Harnett County
420 McKinney Pkwy
LILLINGTON, NC 27546
Phone:
Fax:

SUBJECT: BRES2004-0011
BUILDING RESIDENTIAL

Here are the results of all Inspections located at **165 CRESTHAVEN DR:**

Drawing file: BRES2004-0011 / Updated Drawing for Cresthaven.pdf

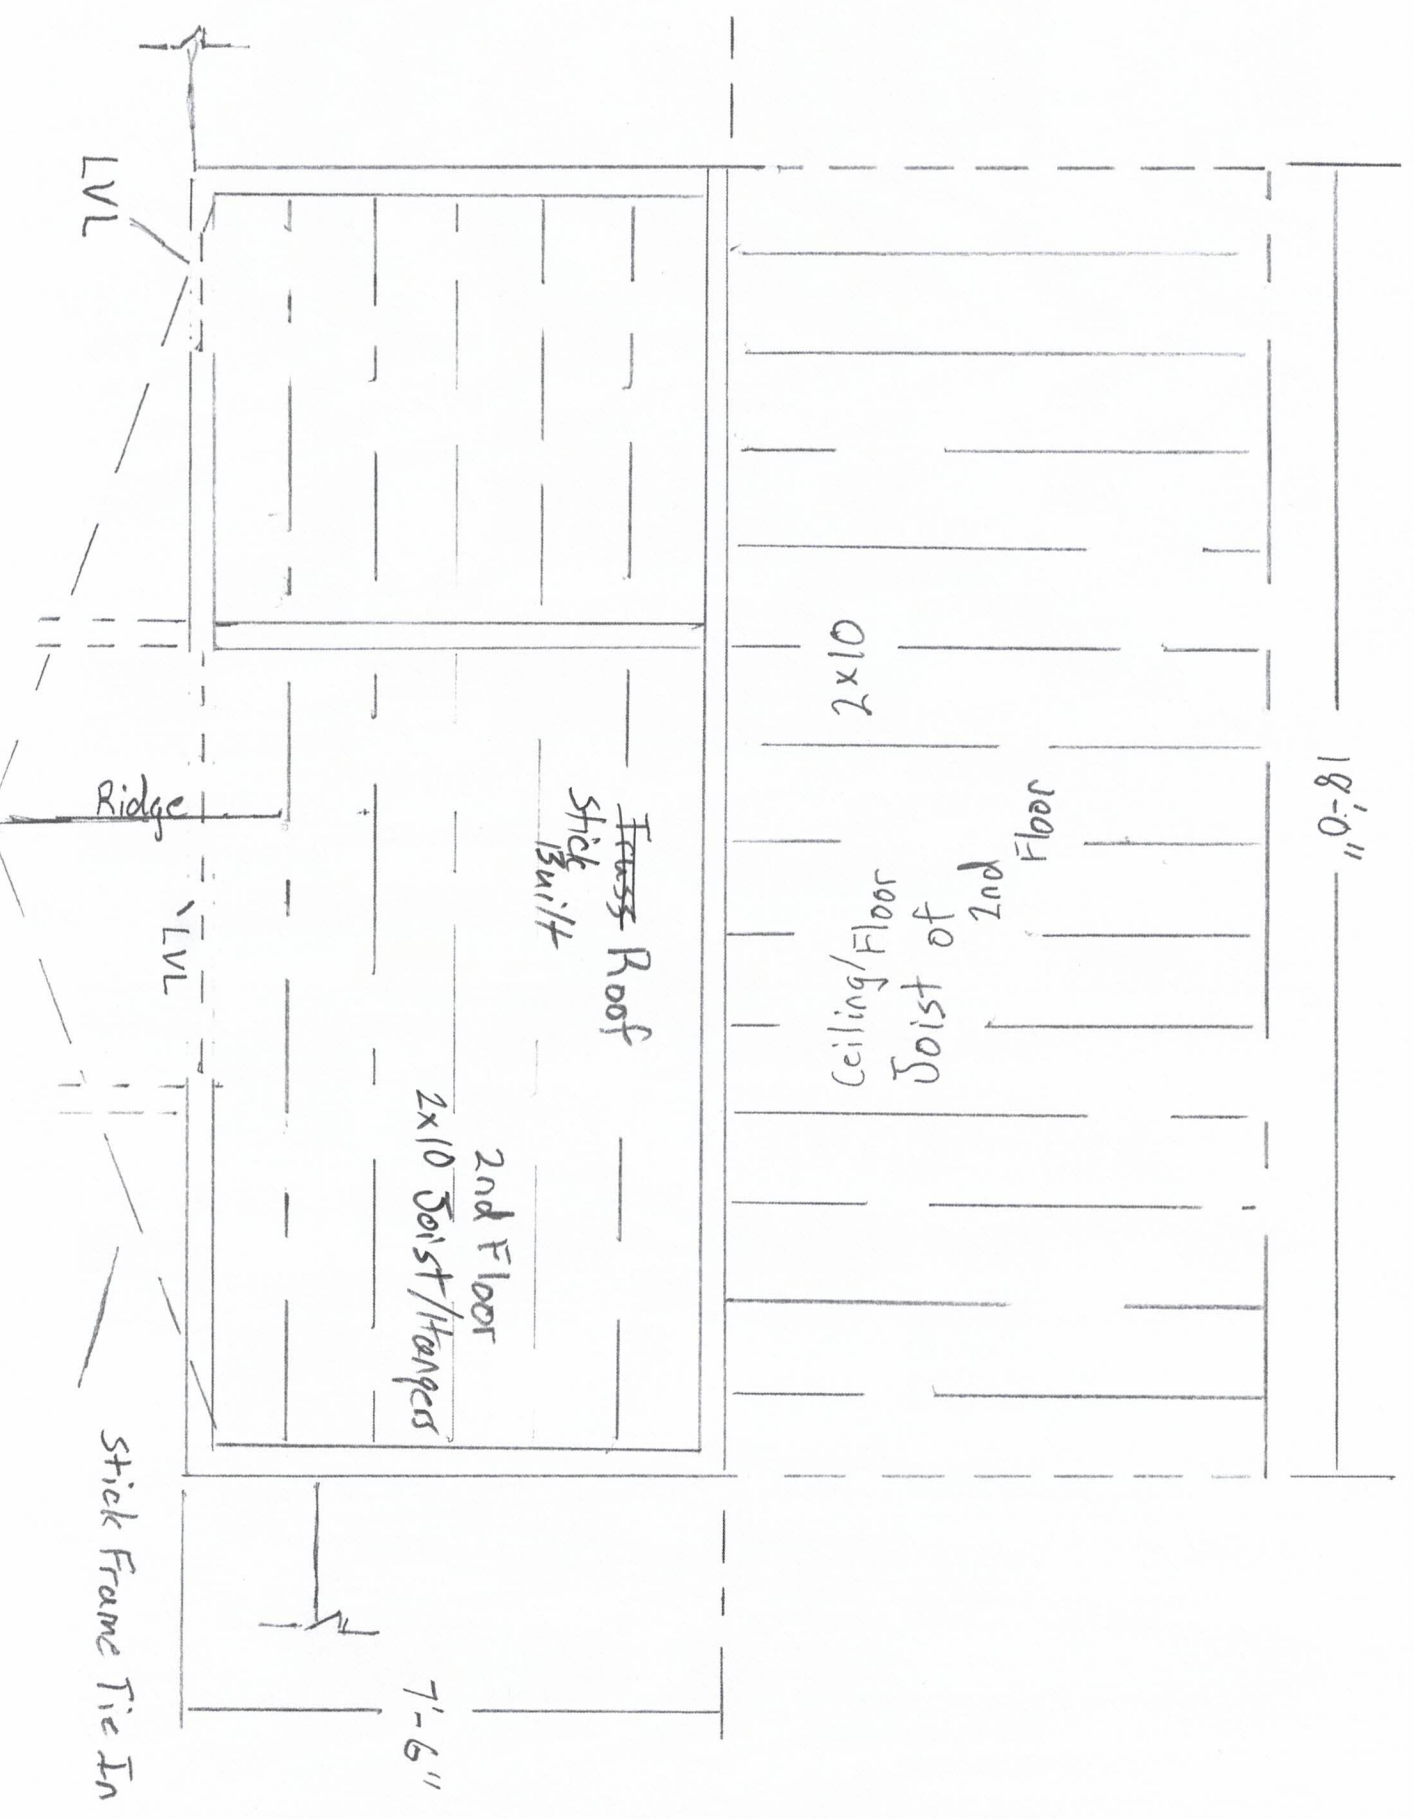
Inspection Type: OPEN FLOOR
Scheduled Date/Time: 7/1/2020
Completed Date/Time: 7/1/2020
Inspector: Steven Gazlay
Result: DISAPPROVED
Remarks:
Notes: Inspector SBL changed the inspection assignment from SBL to SPG
Must schedule Foundation inspection. Remove soils from piers and foundation to verify projection. Engineered plans call for double 2x10 girder, double 2x8 girder installed, either replace with proper size or provide engineering letter.
